KITTITAS COUNTY DEPARTMENT OF PUBLIC WORKS

MEMORANDUM

TO: Community Development Services
FROM: Taylor Gustafson, Environmental/Transportation Planner TG
DATE: May 10, 2019
SUBJECT: Public Works review of Prelim Long Plat LP-17-00004 (Commons at Dry Creek)
Note: Also referenced as Planned Unit Development PD-16-0001

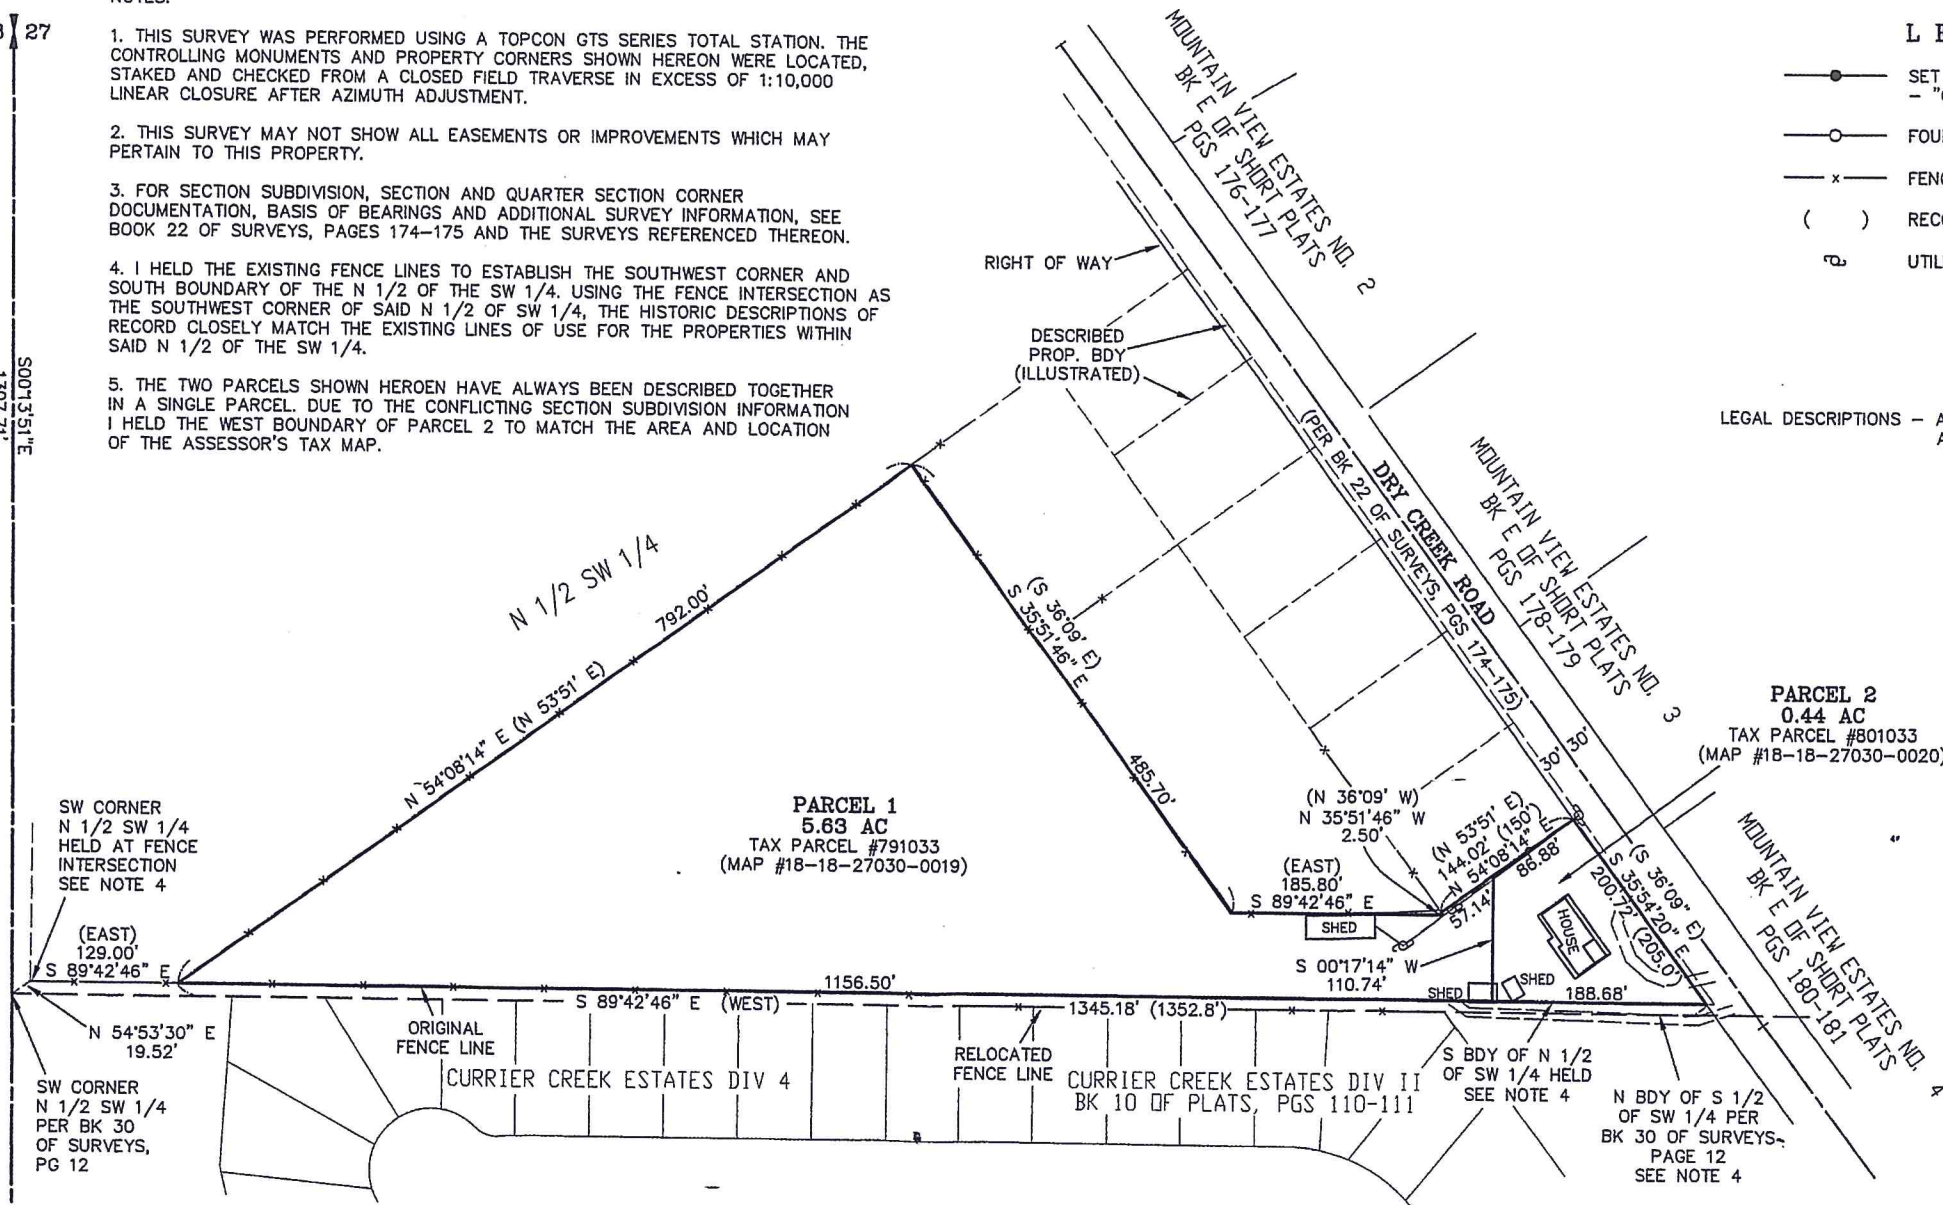
The applicant is notified that the recorded survey referenced in the letter does not meet the requirements of a Preliminary Plat. The requirements of a Preliminary Plat can be found in Kittitas County Code, Sections 16.12 and 16.24.

1. The Preliminary Plat has not been prepared by a licensed Land Surveyor.
2. The Surveyors certificate should be shown on the face of the Plat.
3. The Legal description of the subject property should be included.
4. The vertical datum utilized for the contours should be noted. If the datum used is an assumed datum, the benchmarks utilized should be noted, together with the benchmark elevations.
5. The basis of bearings should be shown.
6. The survey equipment and procedures statement should be shown.

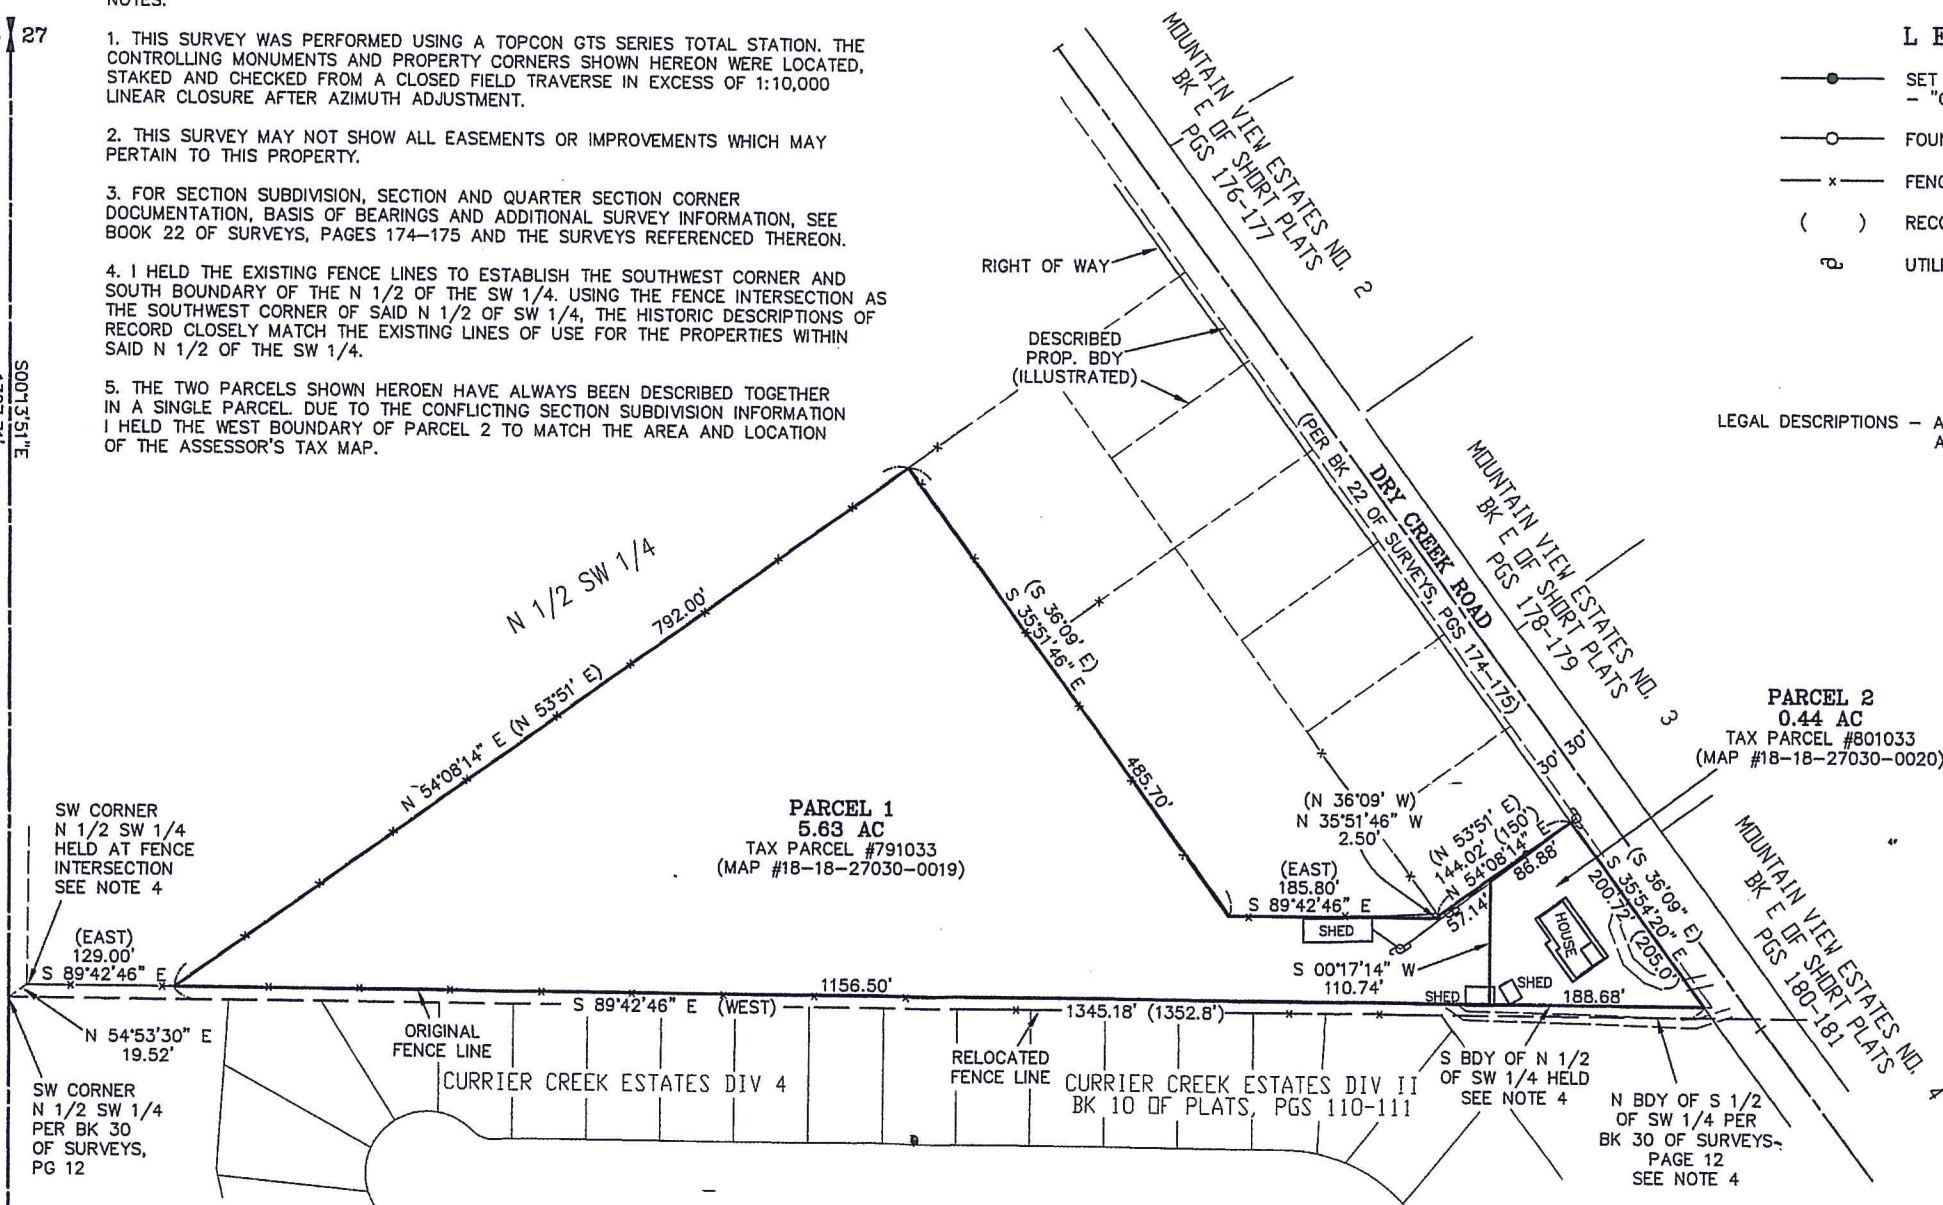
7. BSBL is not included in the Legend.

8. The easement through the adjacent parcel will need to be created via a separate document and referenced on the face of the Final Plat. The adjacent parcel is zoned Urban residential, with a side yard setback of 15 feet to boundaries or easements. This appears to fall quite close to the existing building, and as such, the distance between building and easement line should be noted.
